DEVELOPMENT REVIEW BOARD
TRANSPORTATION DEVELOPMENT

DRB Project Number: 1001523
Ladera Business Park-
Las Lomitas Plaza

SUBJECT: Site Plan for Building Permit

DRB Project Number: 1001523 Hearing Date: 03-21-2018
 Project: Ladera Business Park, Lots 15 & 16, Unit 1 – Las Lomas Plaza Agenda Item No: 3

SHEET: A001
 Sheet 1 of 9

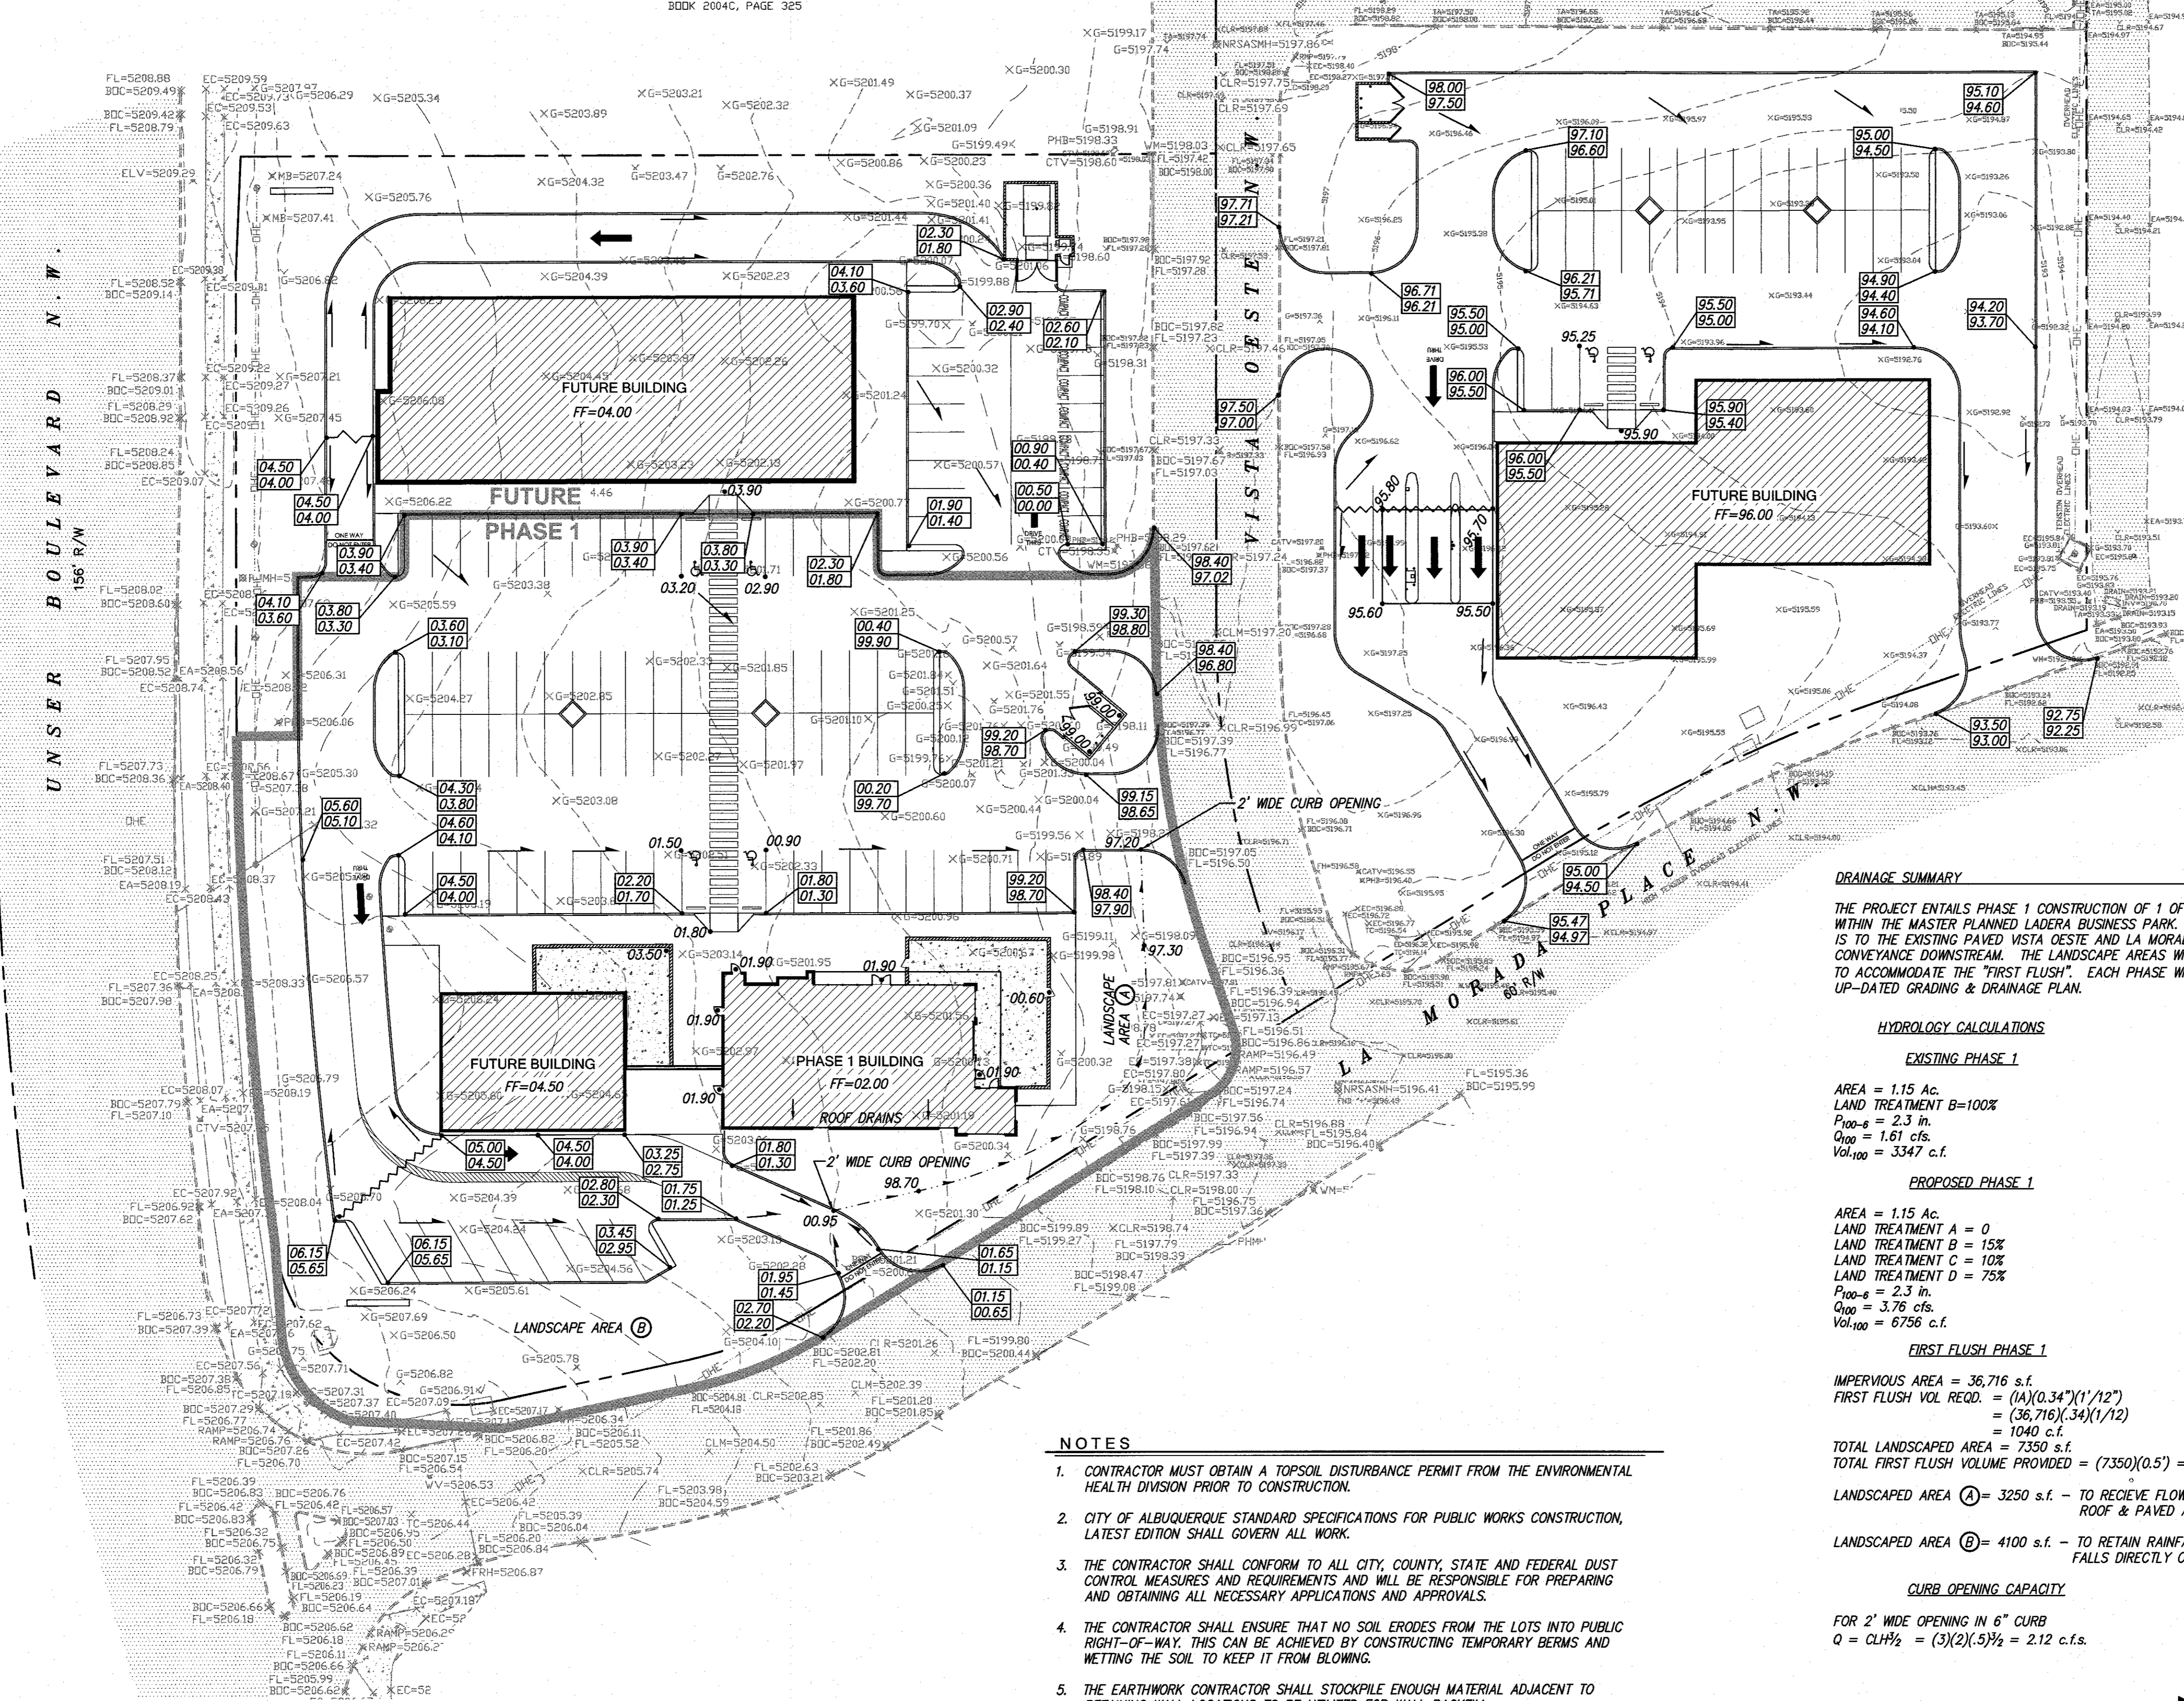
1. Adjust ~~site to remove~~ the one-way only access to La Morada.
2. Provide a detailed phasing plan for building permit.
3. Parking spaces cannot cross over lot lines.
4. Provide dimensions behind the ADA access ramp at ADA parking to ensure sufficient turn-around area. (Including building 1)
5. Please include a copy of your shared access and parking agreement.
6. Please specify the City Standard Drawing Number when applicable.

*Addressed @ hearing
Kym will withhold signature until plat is complete*
